From: Sue Howell
Sent: 29 November 2017 10:46
To: Planning.Responses
Cc: Anita Gardner
Subject: RE: Planning Consultation on LU/211/17/DOC

Comment from Greenspace

APPLICATION LU/211/17/DOC
NO:

Registered: 23-JUN-17
Site Address: 6 & 7 Courtwick Park Cottages Courtwick Lane
Littlehampton BN17 7PD

1120 / 01

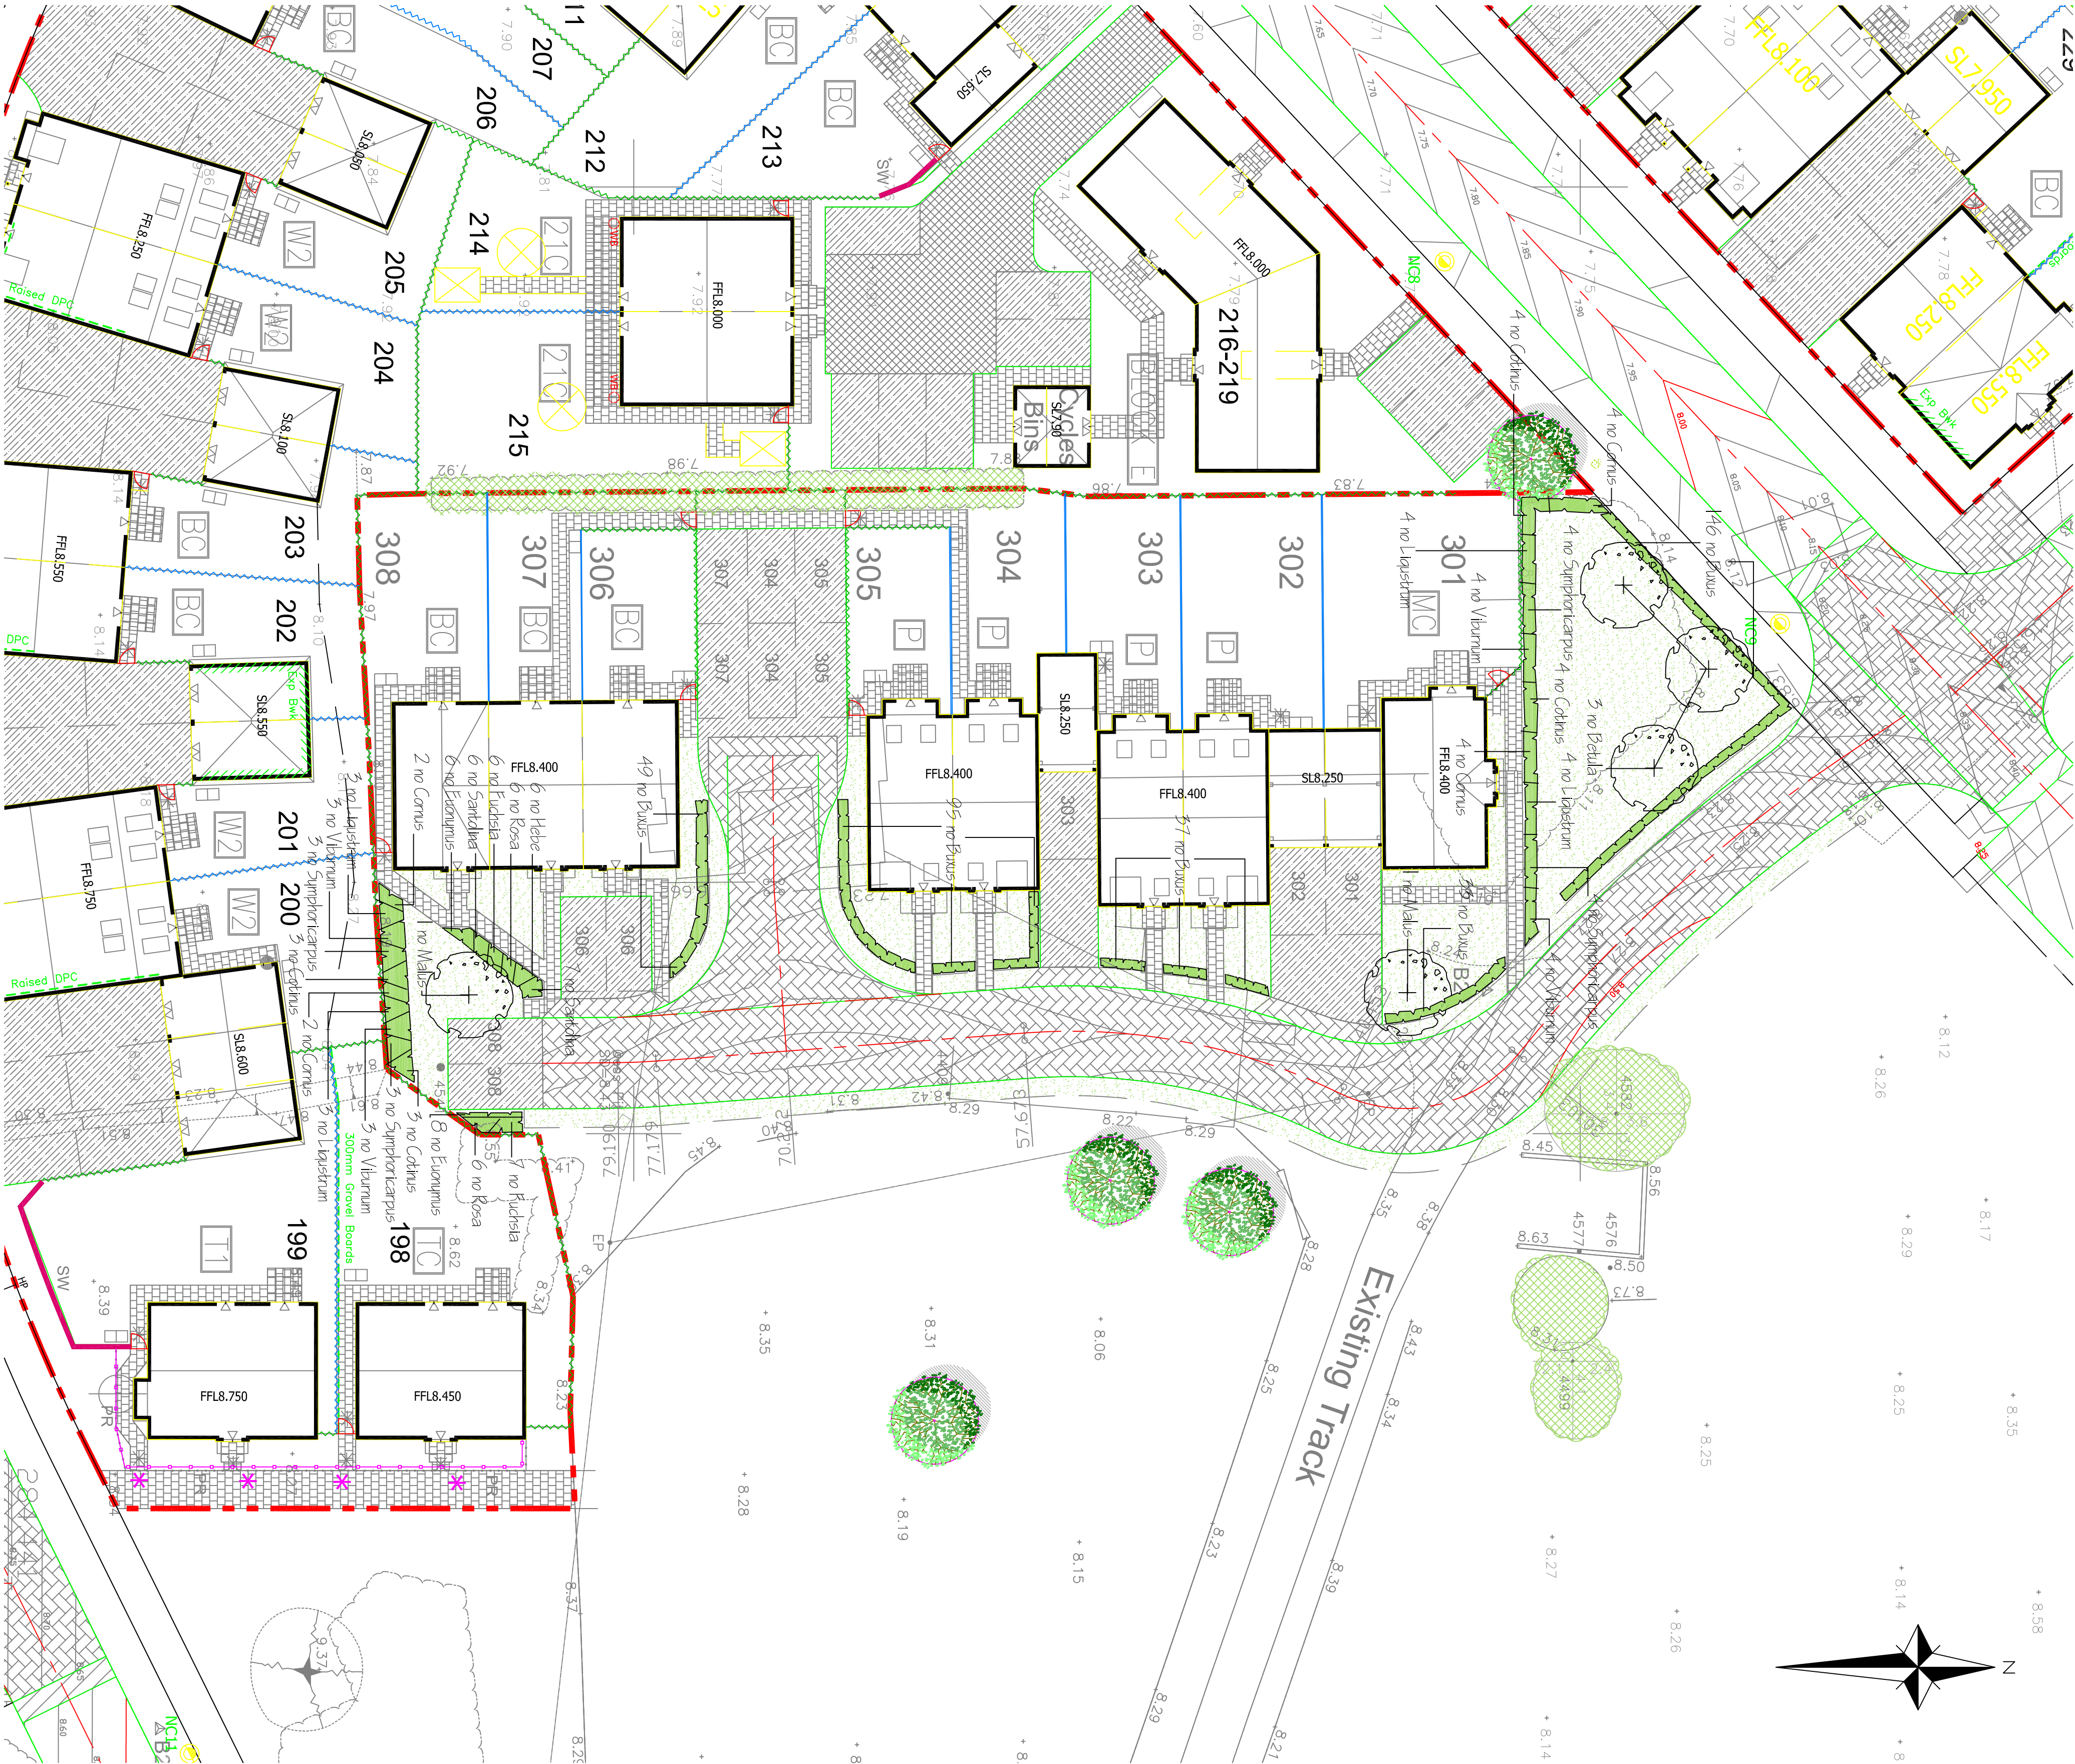
Further to submission of drawing No 1120/01 Rev B Planting Plan, we can confirm that the information supplied does propose a well thought out and comprehensive scheme which now contains the appropriate information regarding quantities proposed and is fitting for location and therefore we would **recommend the discharge of Condition 4 Landscaping reserved by condition imposed under planning approval LU/24/17/PL on this application LU/211/17/DOC.**
